**Application No:** WSCC/066/14/AW  
**Proposal:** Replacement of existing entrance canopy and provision of new canopy outside newly formed classrooms.  
**Location:** Rose Green Infant School, Hawkins Close, Bognor Regis, West Sussex, PO21 3LW  
**Grid Ref:** 490055 098853

Application No: WSCC/066/14/AW  
**REGULATION 3**

**Replacement of existing entrance canopy and provision of new canopy outside newly formed classrooms. At Rose Green Infant School, Hawkins Close, Bognor Regis, West Sussex, PO21 3LW**

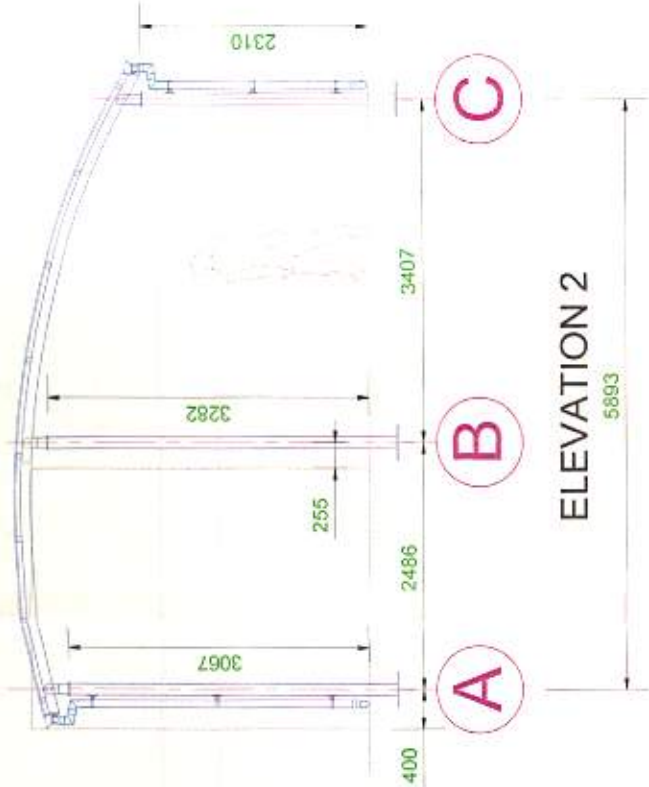
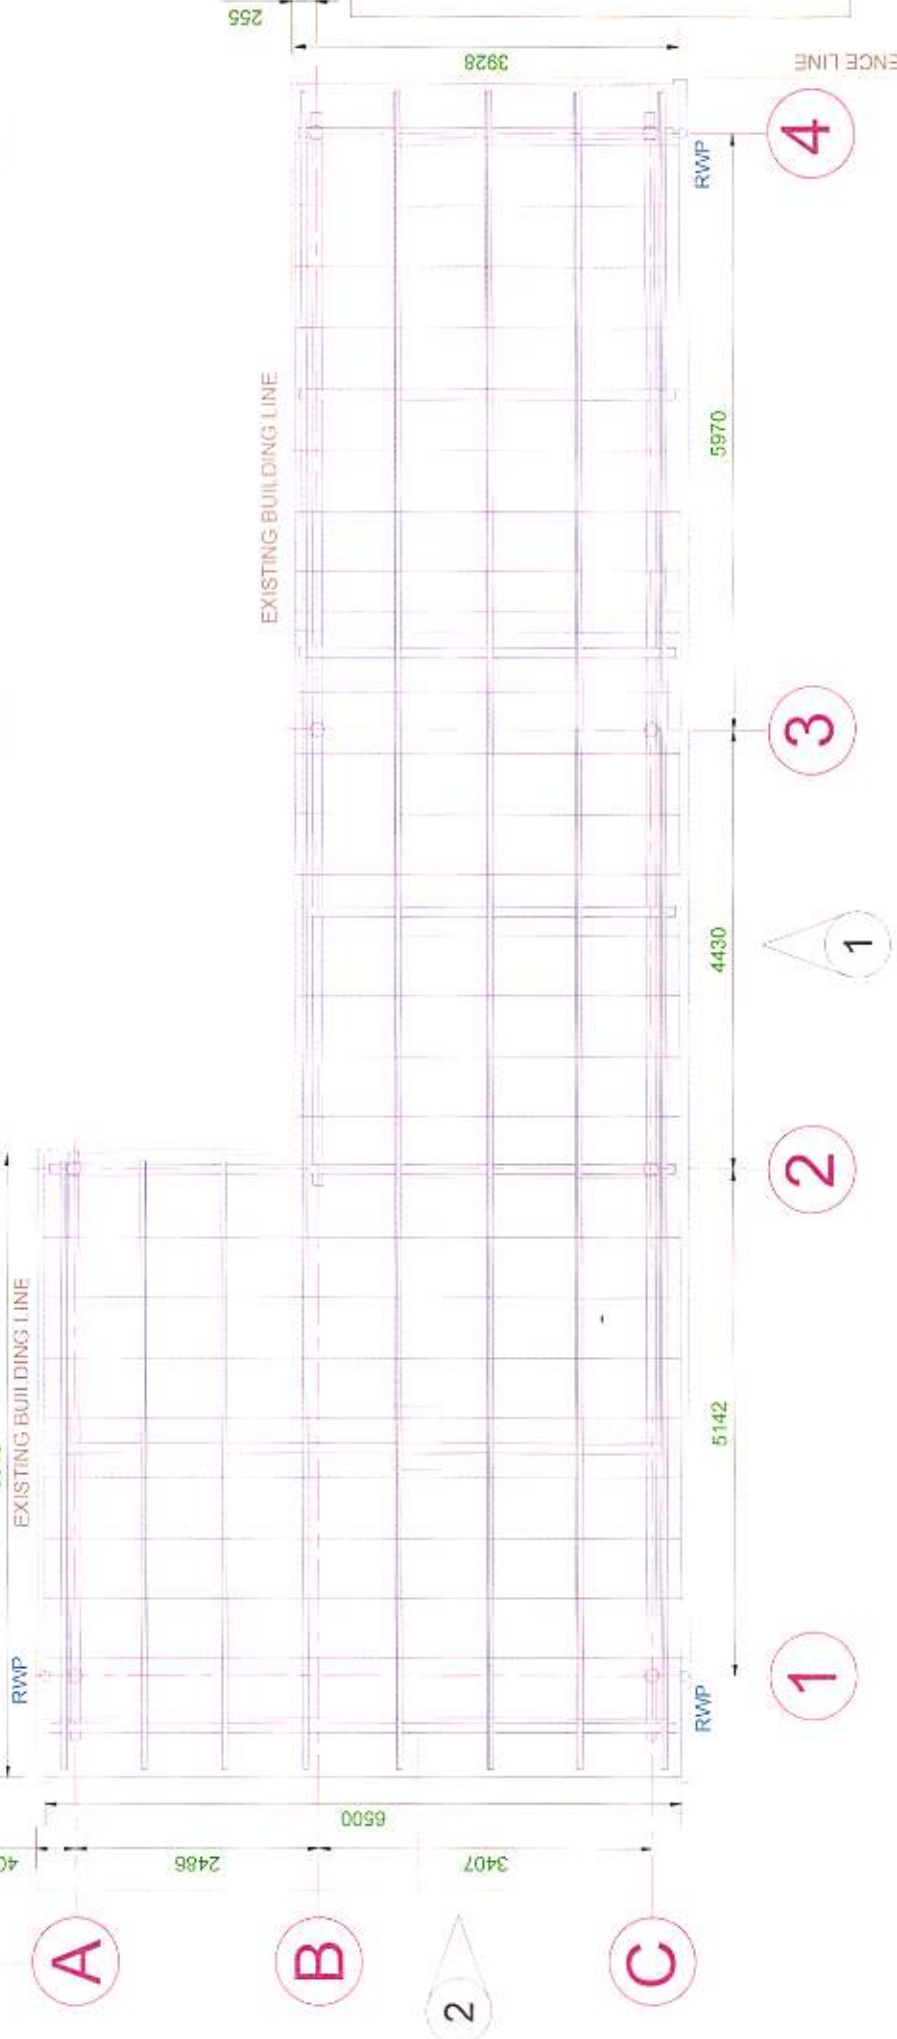
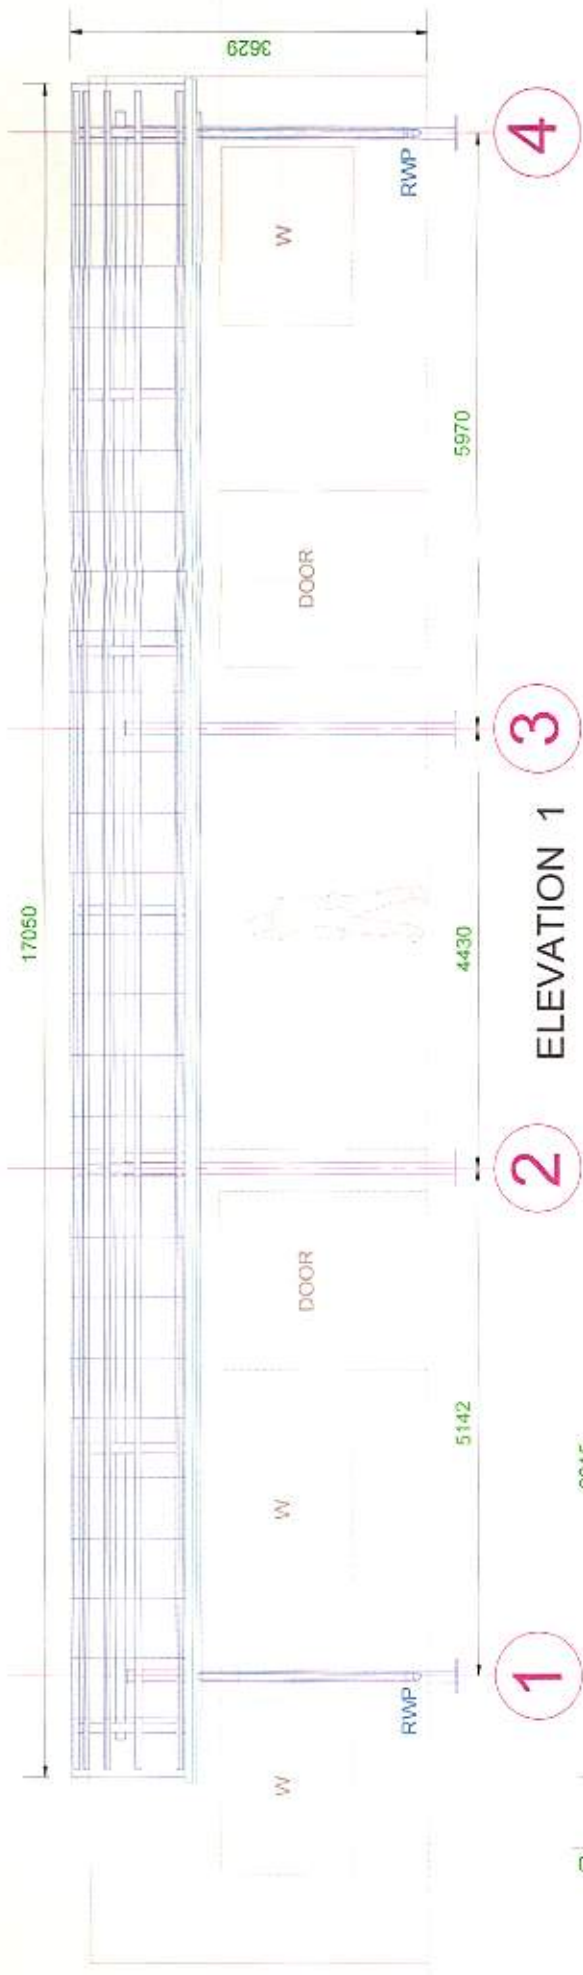
3. No development shall be carried out until details of the colour(s) to be used for proposed canopy has been submitted to and approved by the County Planning Authority. The development shall thereafter be carried out in accordance with the approved details.
